NSW RURAL FIRE SERVICE

9 October 2019

Proposed Development of Lane Cove West Data Centre at 1 Sirius Road Lane Cove West

MASTER PLAN

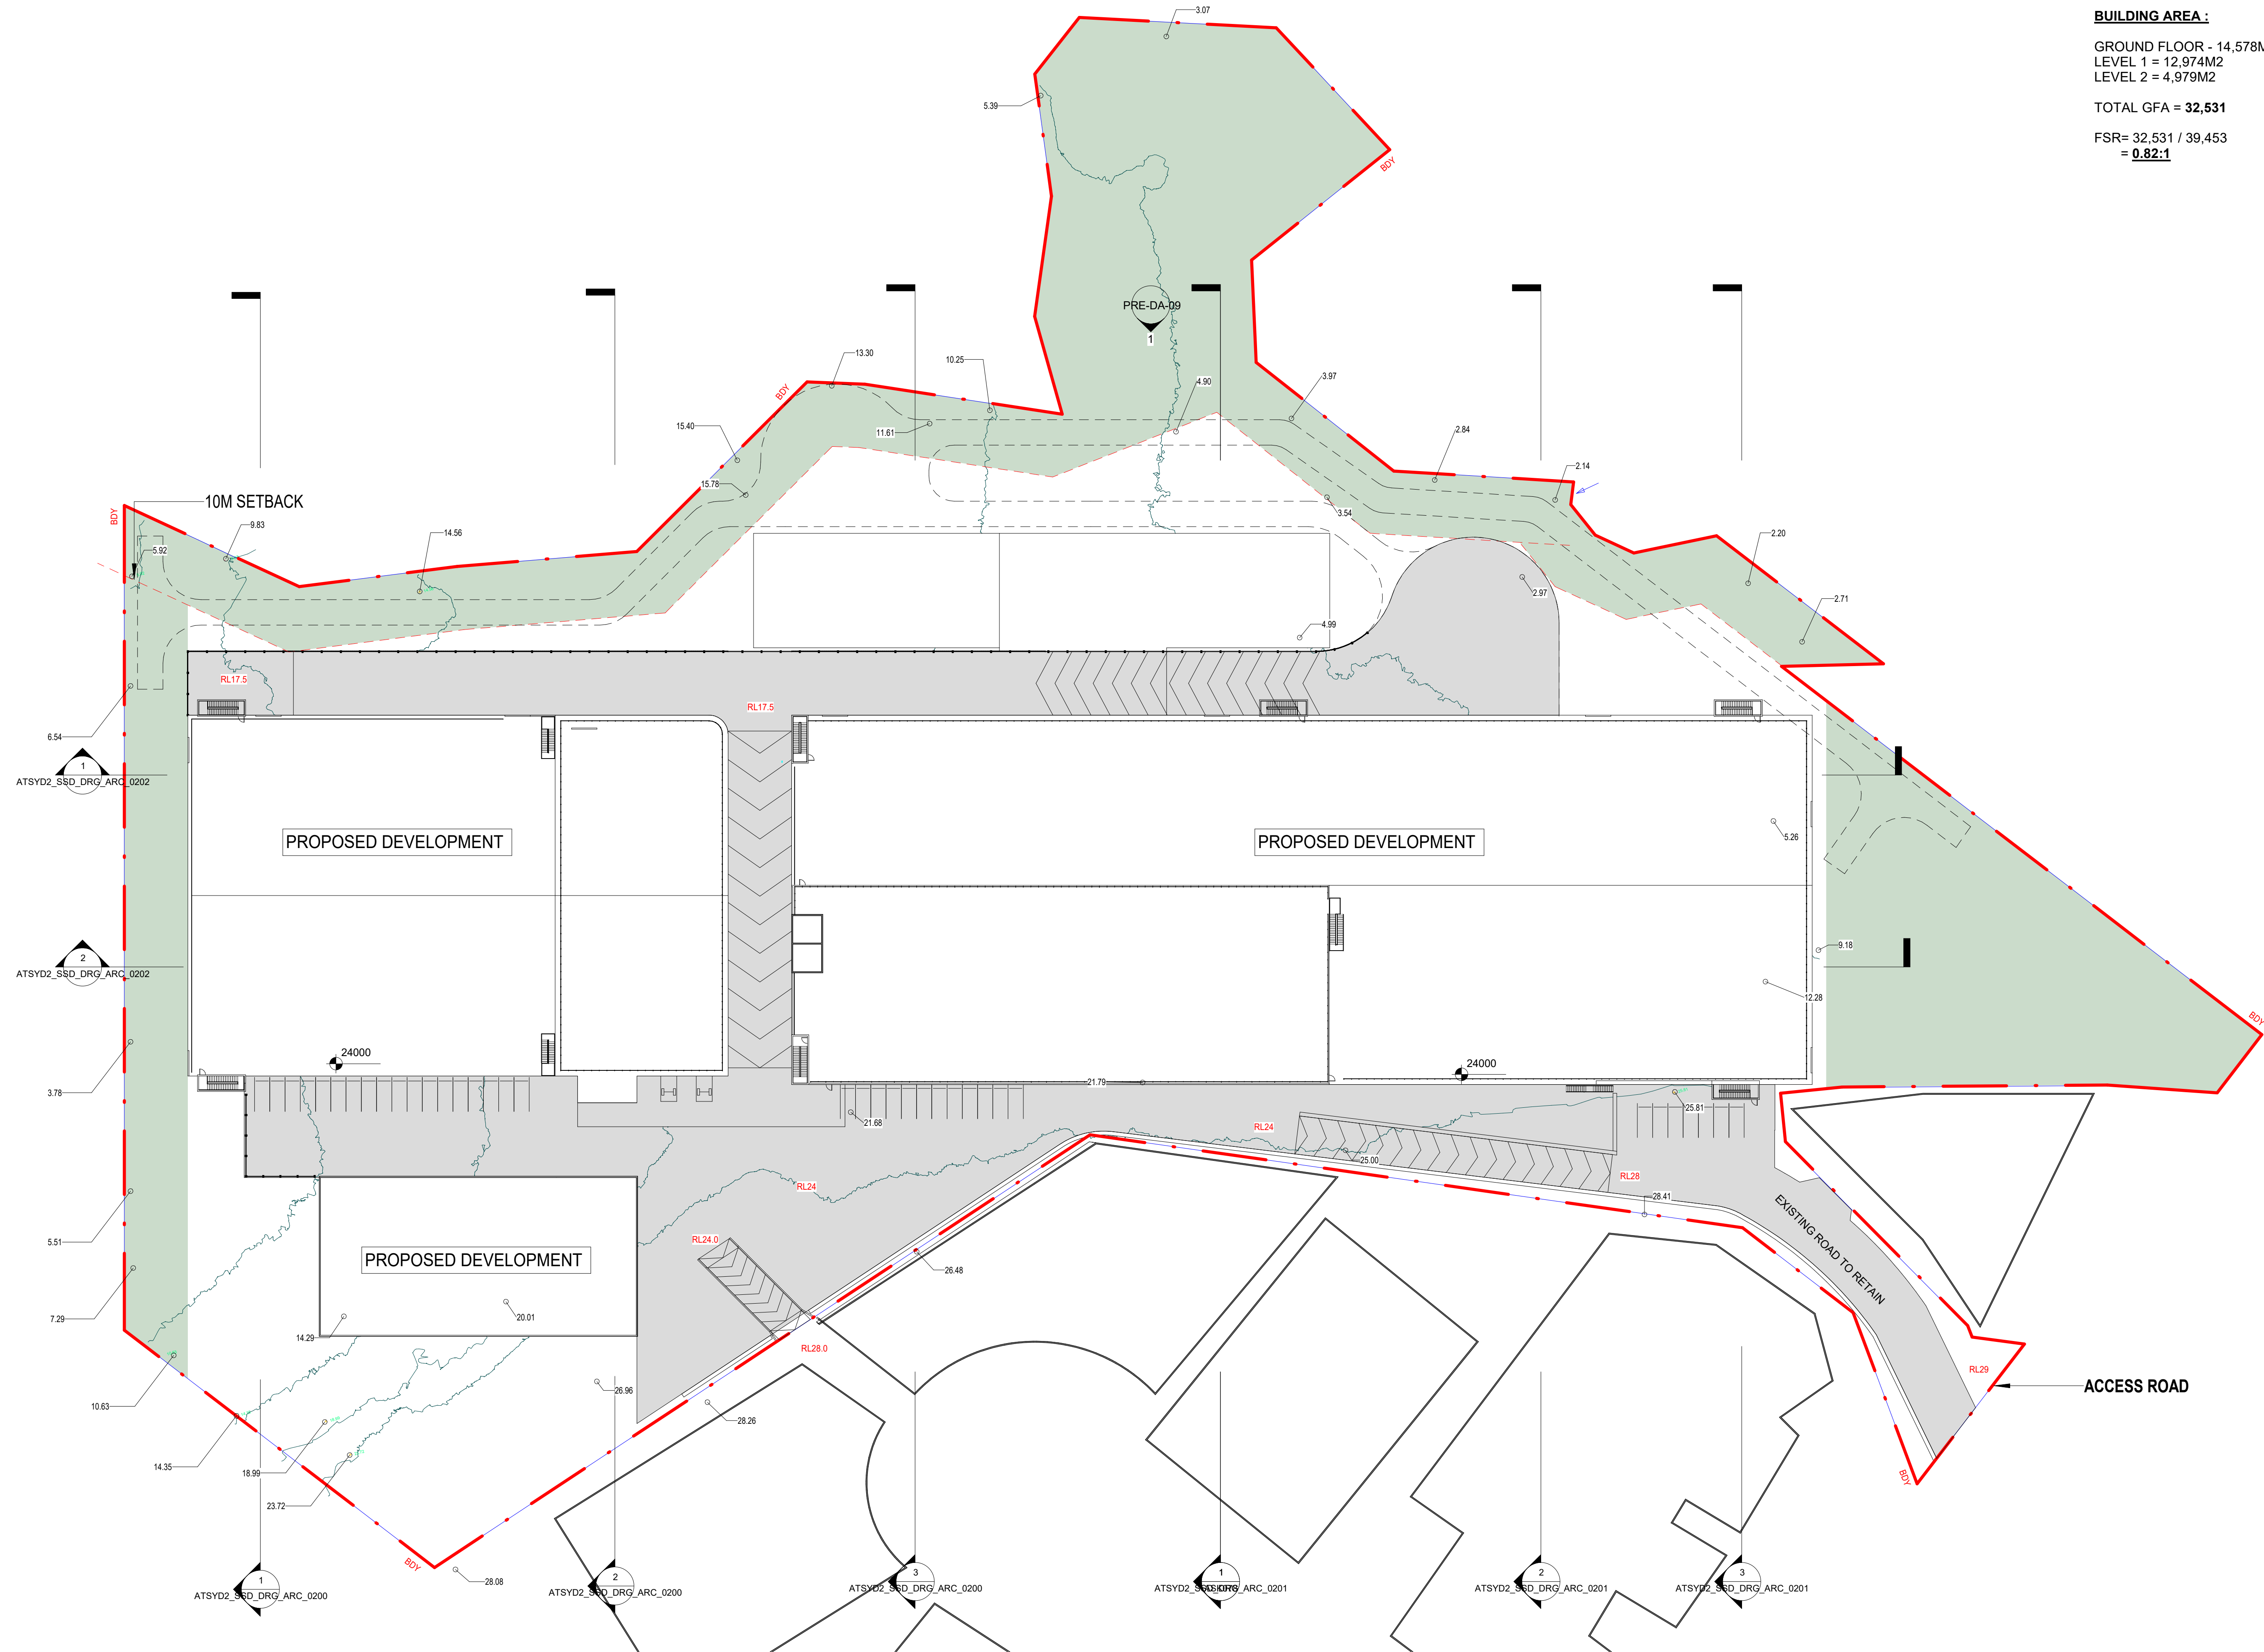
- The proposed fuel storage tanks in their current locations are considered to have the potential to generate or accelerate bush fire risk to adjacent buildings on and off site and to emergency personnel when defending the property during bush fire events. Additional bush fire protection measures (either within *PBP*, *Australian Standard 3959 -2009 Construction of buildings in bushfire-prone areas* or *Building Code of Australia*), such as constructional standards and design provisions, to support the location and suitability of the proposed diesel fuel tanks need to be provided given these are possible ignition points and fuel sources.

- Additional information to address safe access to the proposed buildings, with regard to the location of part of the proposed vehicular access on the south western elevation of the Data Centres in the form of an elevated driveway, needs to be provided. This driveway is partially located above Generator Platform No 1 (diesel fuel tanks located below) which in the course of a bush fire event might impact adversely on the safety of fire fighters either fighting the fire or accessing or egressing the site.

A revised and updated bush fire protection assessment is required for further assessment of the proposal against the provisions of *Planning for Bush Fire Protection (PBP) 2006* or any subsequent versions, particularly in respect of the following factors:
